# CITY OF ALBUQUERQUE

**RE: Popeyes – Juan Tabo  
Grading & Drainage Plans  
Engineer's Stamp Date: 09/13/2024  
Hydrology File: K22D035A**

Based upon the information provided in your submittal received 10/01/2024, the Grading & Drainage Plans are **not** approved for Building Permit, Grading Permit. Please address the following comments prior to resubmittal.

GRADING PLAN
SCALE: 1" = 20'

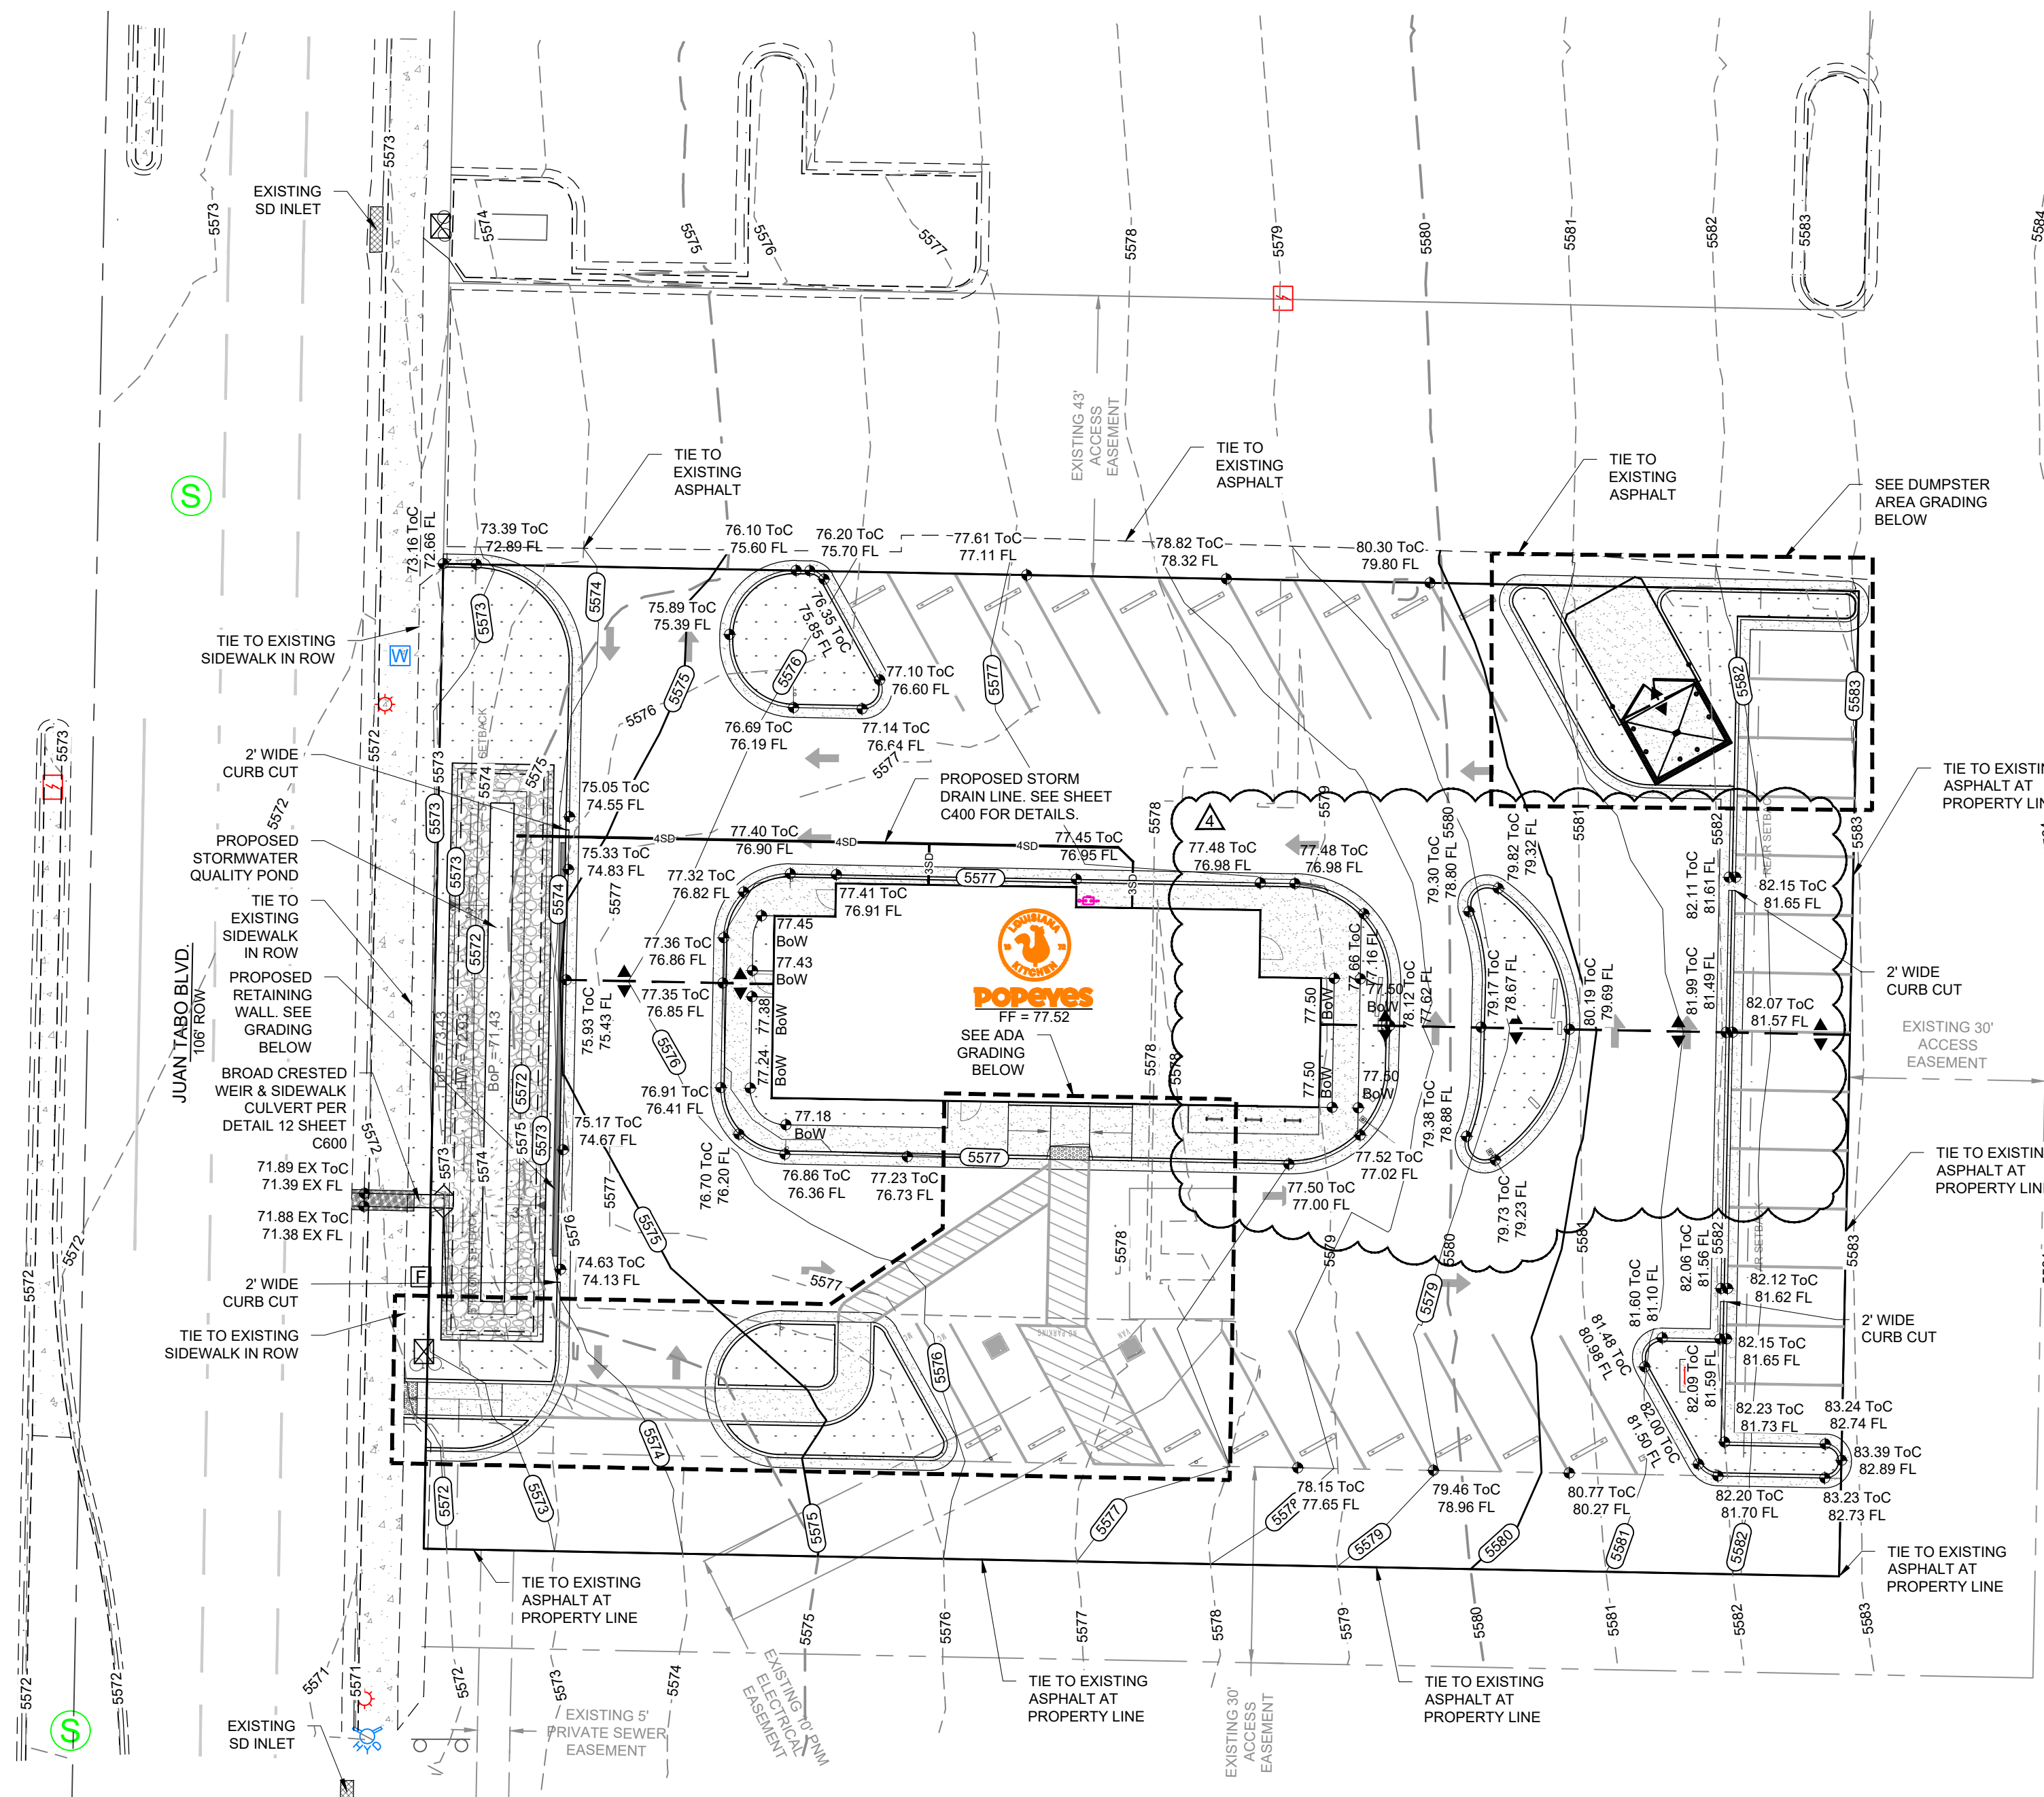
3. Provide a cross-section of the proposed Broad Crested Weir from the SWQ pond to the face of the existing concrete curb in the Juan Tabo Blvd. Right-of-Way.

4. Stormwater discharges across the sidewalk are not allowed on collector roads and above: provide sidewalk culverts or drain lines through the curb.
5. Please reference City of Albuquerque Standard Detail No. 2236 – Sidewalk Culvert with Steel Plate Top at the sidewalk culvert.

6. An SO-19 Permit will be required and should be included on the request. Please include the [Standard SO-19](#) notes on the grading plan.
7. For trash enclosures serving food service developments, trash enclosures must demonstrate control of liquids from dumpster areas per DPM by containing runoff from the dumpster area, preventing outside drainage from entering the dumpster area, and discharging to the sanitary sewer. Please show an inlet in the middle and label. "Inlet to be connected to the sanitary sewer. See Utility Plan."

CONCRETE WASHOUT NOT TO SCALE

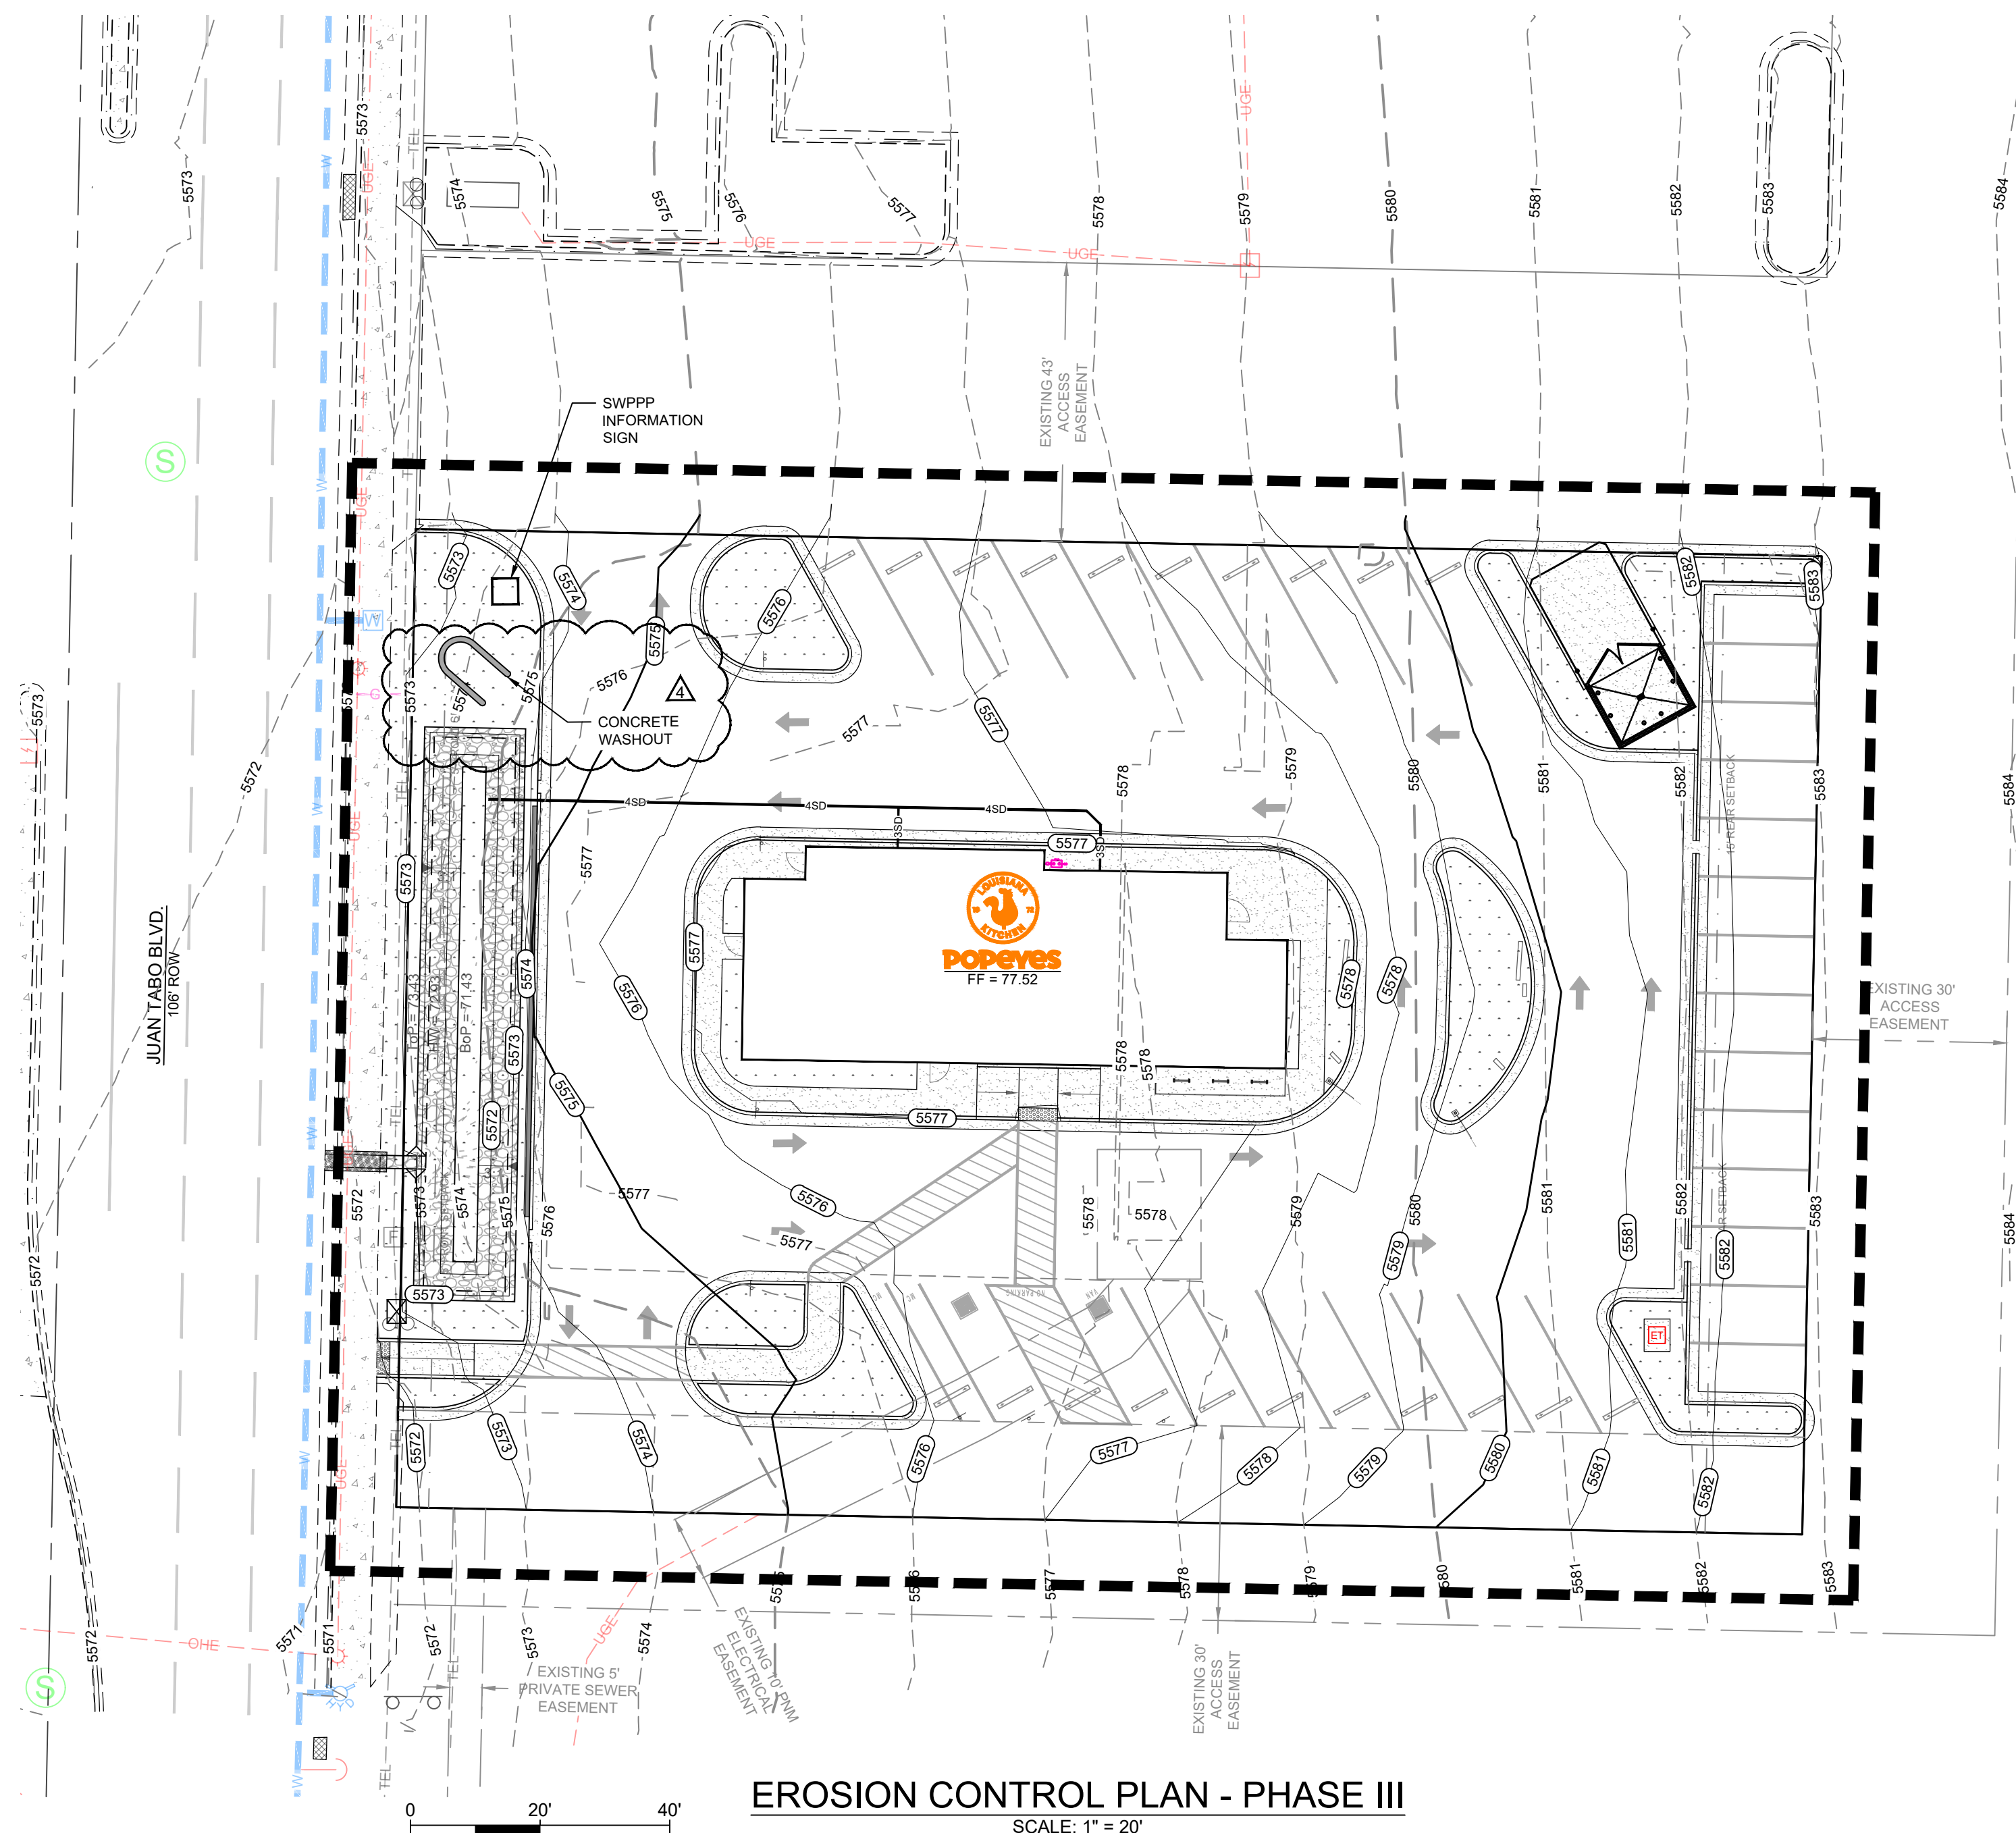
1. Please perform a thorough review of all plan sheets and remove all references to installing fuel storage tanks and fuel islands.
2. Please show the proposed concrete washout location independent of the proposed Stormwater Quality (SWQ) pond.
